Re: Design Advice Letter

This project (**SSD-94409457**) was declared State Significant Development (**SSD**) by the Minister for Planning and Public Spaces on 23 July 2025 per the recommendation by the Housing Delivery Authority (**HDA**) and includes a concurrent Rezoning Proposal to increase the height and floor space ratio permissible on the site. This project seeks consent for a 45-storey residential flat building comprising 63 market dwellings and 51 affordable housing dwellings, ground level communal open space and basement carpark.

GROUND FLOOR (1:200)

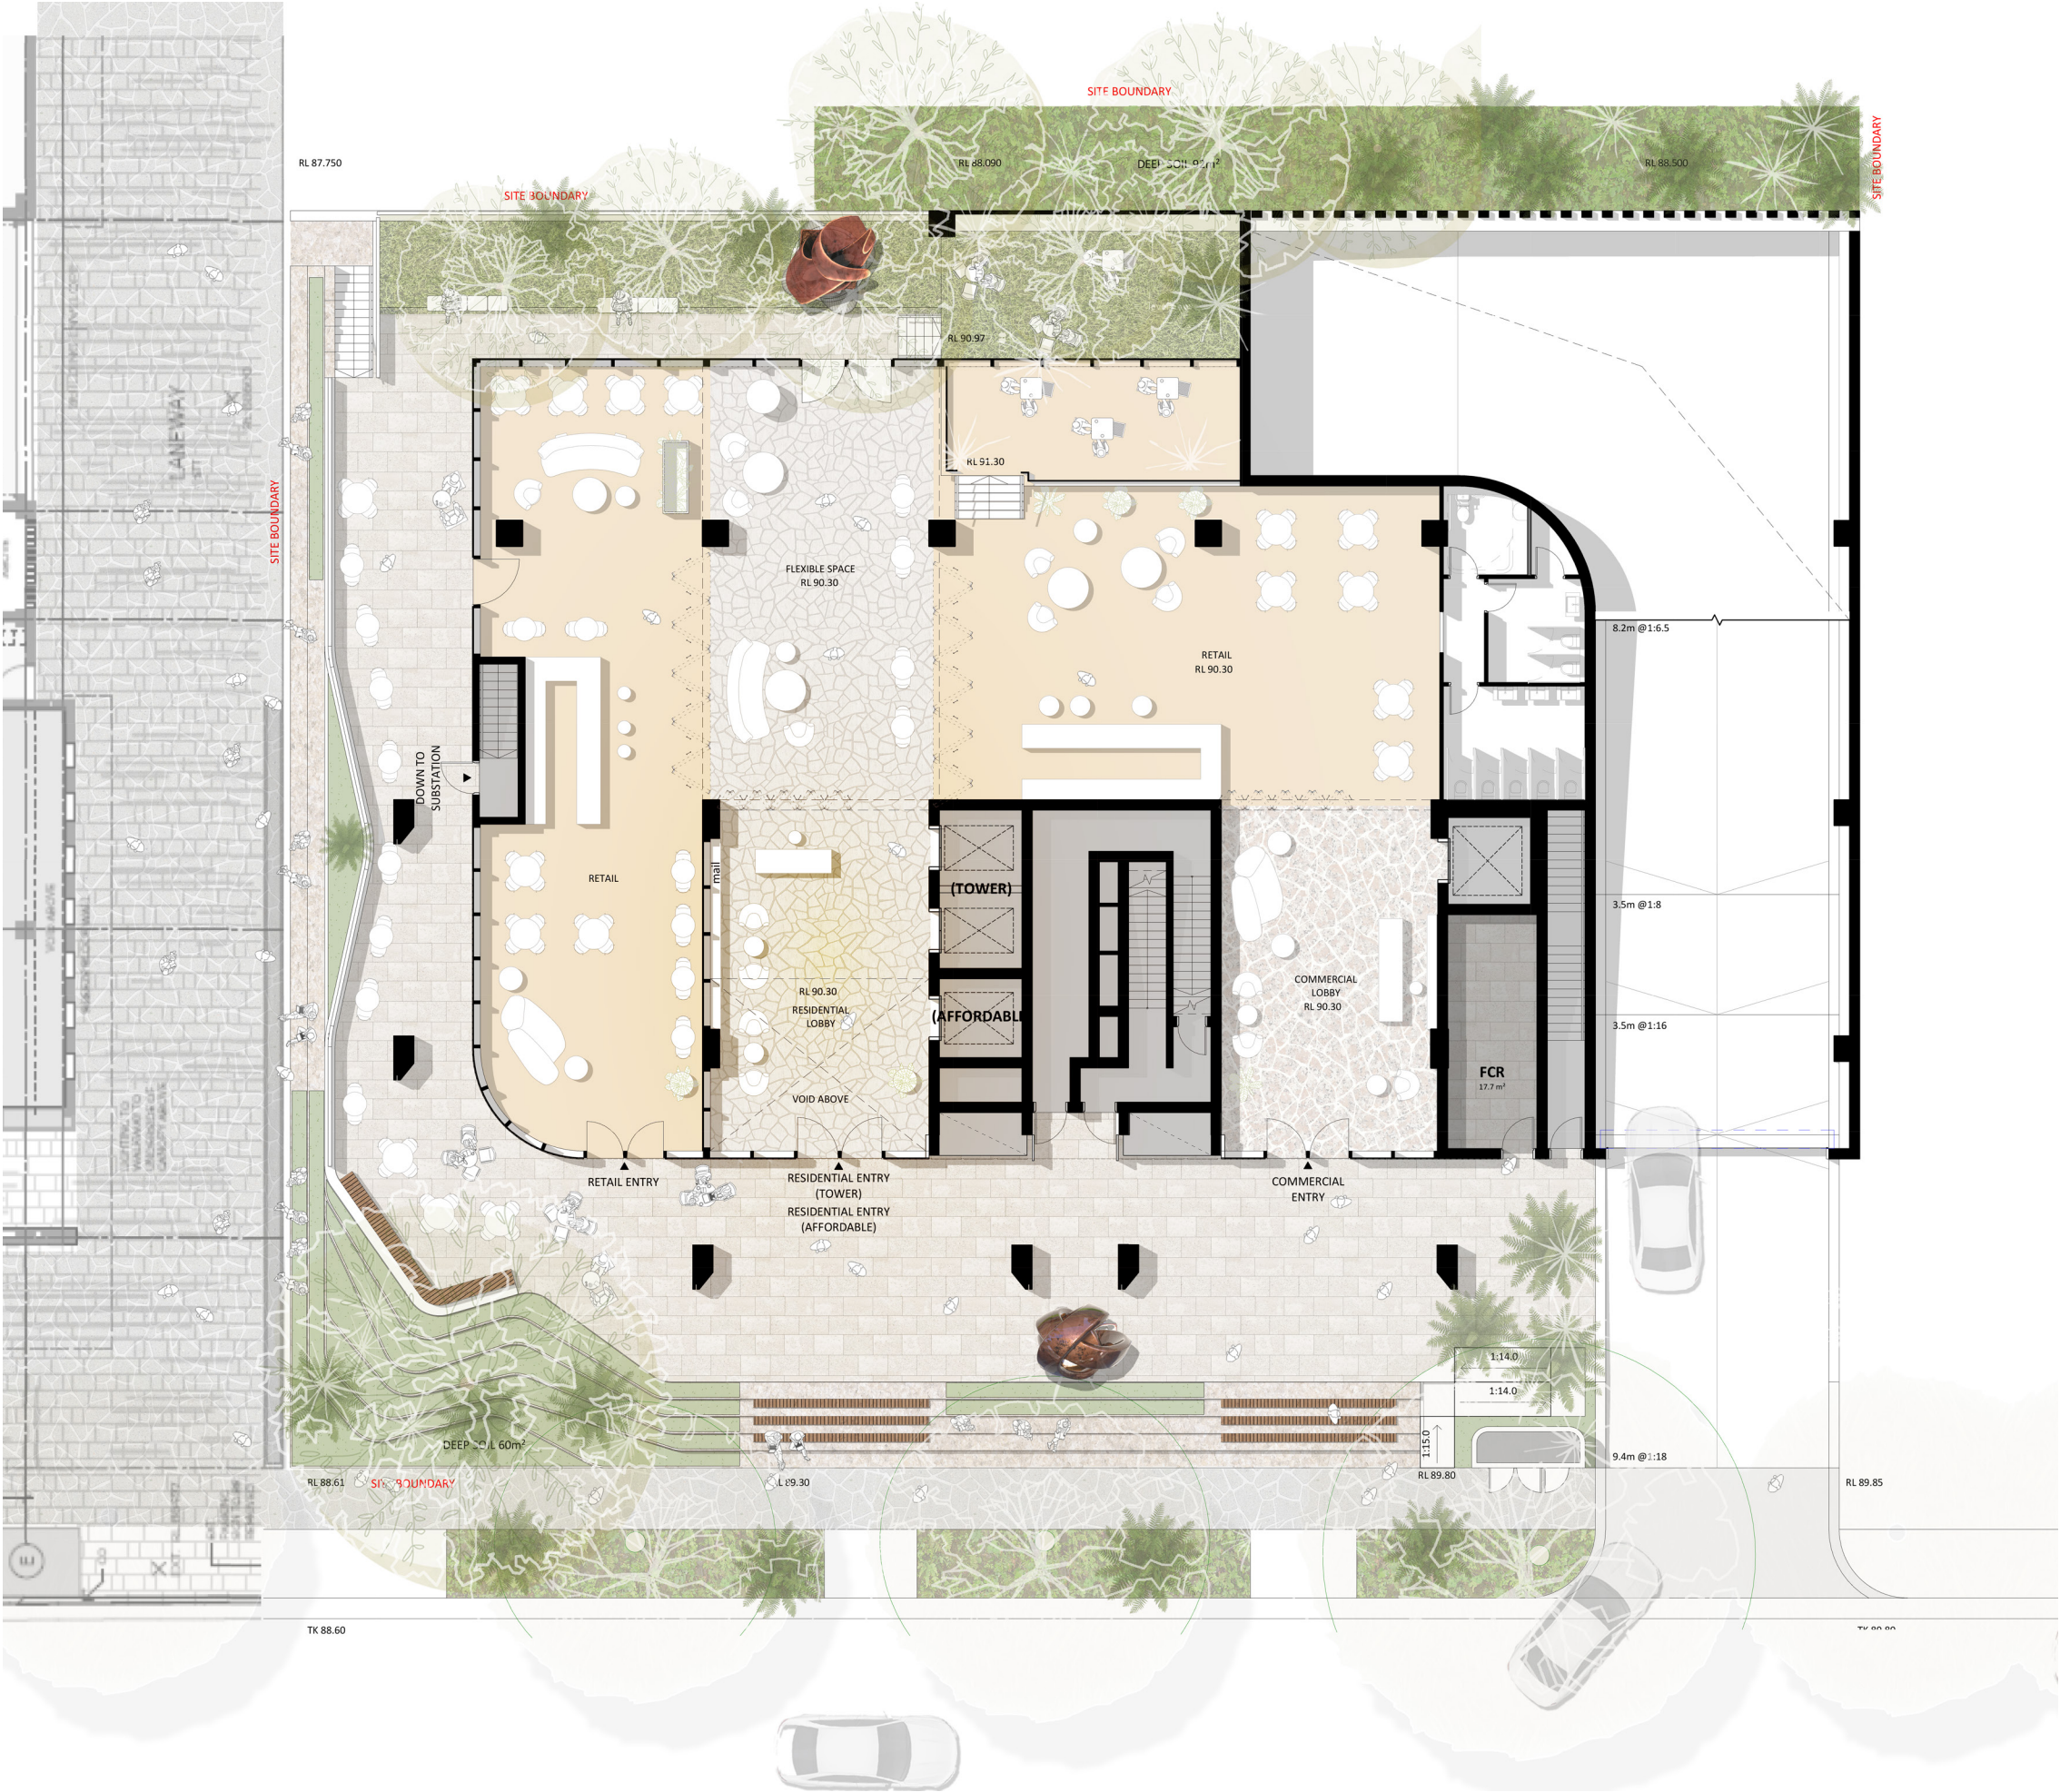
- The current design involves a wall separating the market and affordable housing lobbies.
- Consider access arrangement to communal facilities for affordable housing.
- Incorporate a single fully integrated shared lobby. Any departure from this towards segregation of market and affordable lobbies needs to be evidenced with a compelling operational reasoning for why. DRP notes many similar projects with singular shared lobbies.

- A single fully integrated shared lobby, or evidence with a compelling operational reasoning for any departure
- Reconsideration of awning design to address wind conditions
